Application for a non-material amendment following a grant of planning permission. Town and Country Planning Act 1990

Proposed Solar Farm with associated infrastructure.

H02-0454-14

Replacement of the six transformers and change of colour for the inverters from Holly Green (RAL 14C39) to Pure White (RAL 9010).

Drawing Title:
Transformer/Inverter
Plan and Elevations

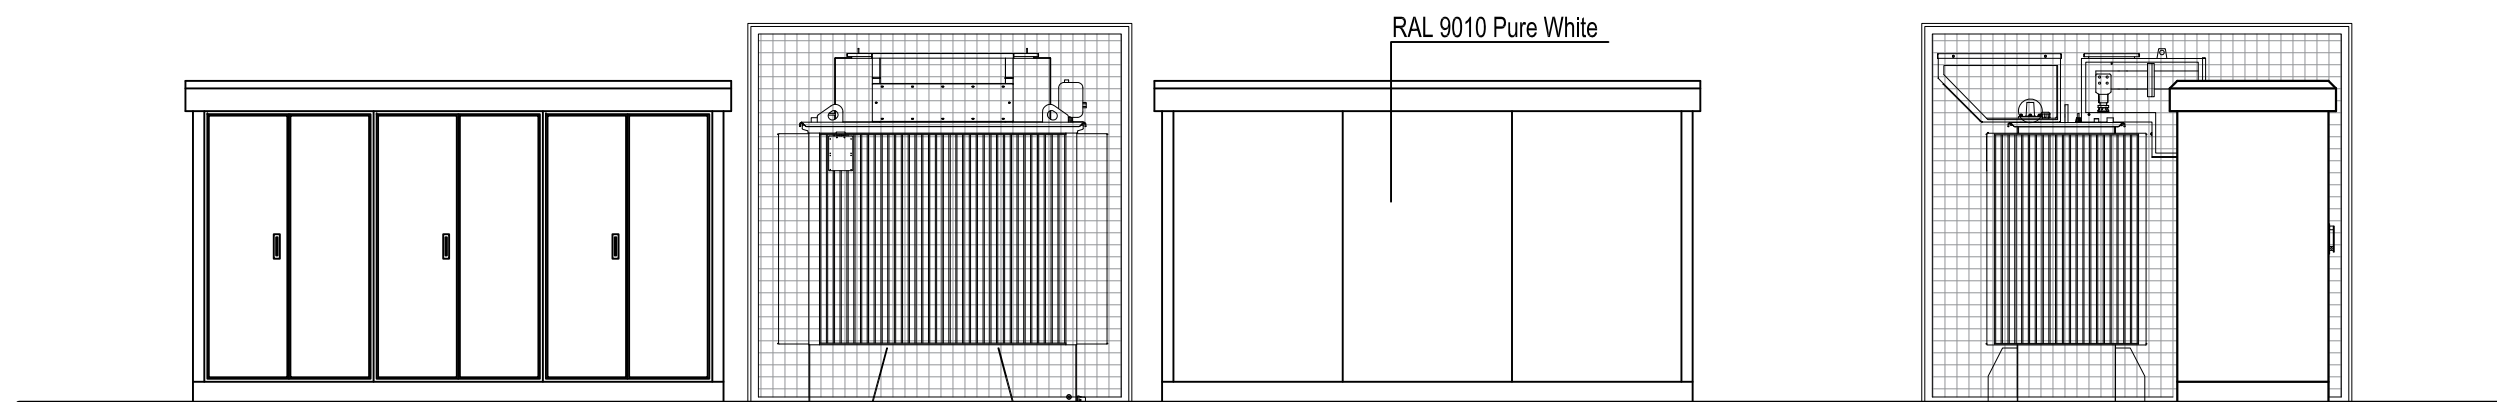
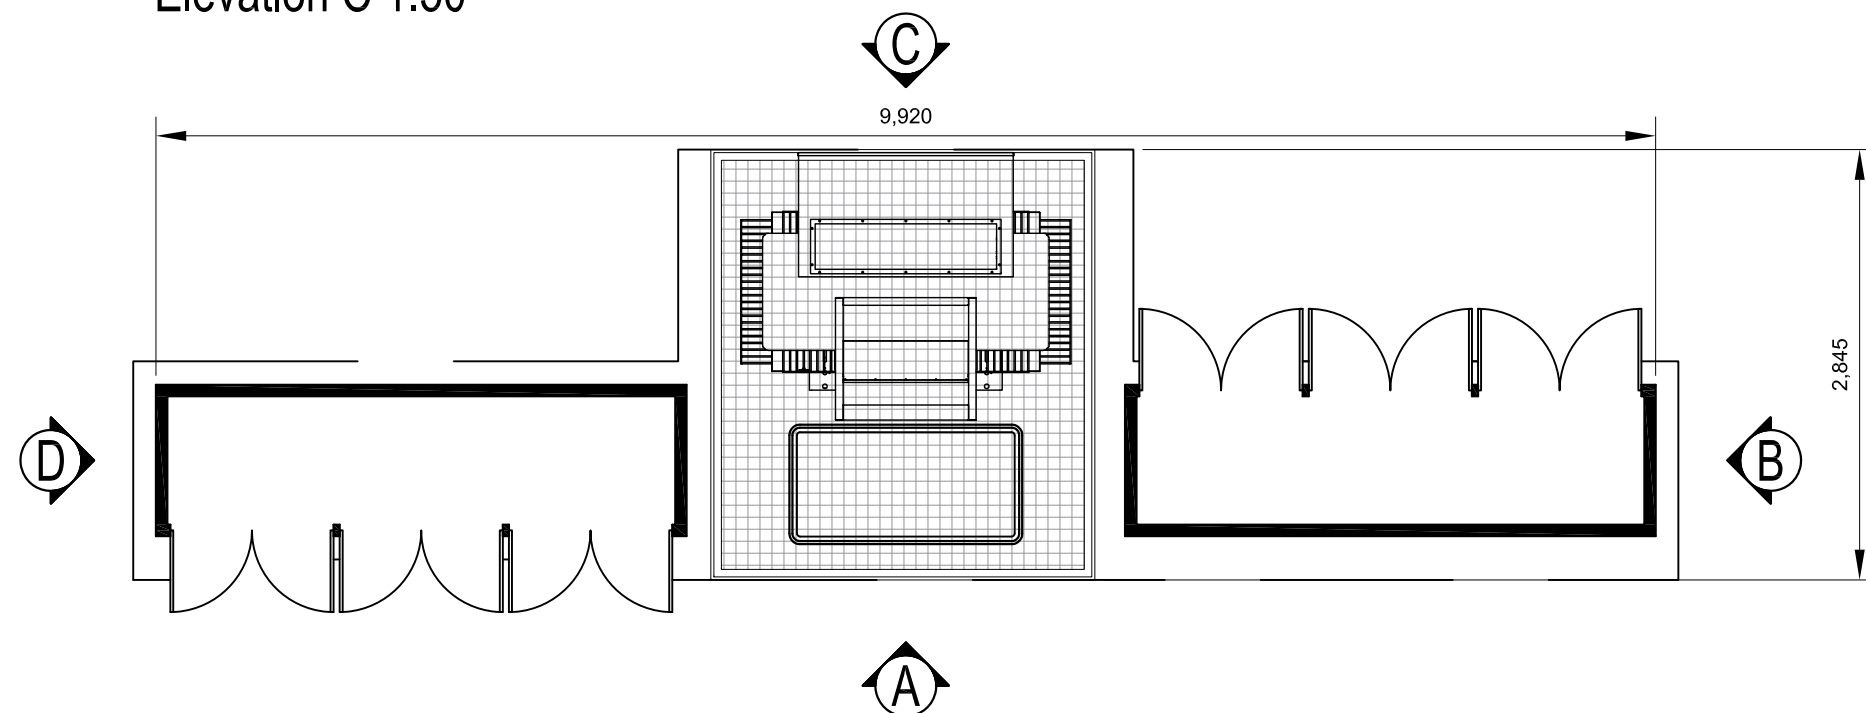
Owing to sourcing and technical reasons, the transformers getting hot within their enclosures, we are looking replace and resource.

PA004C
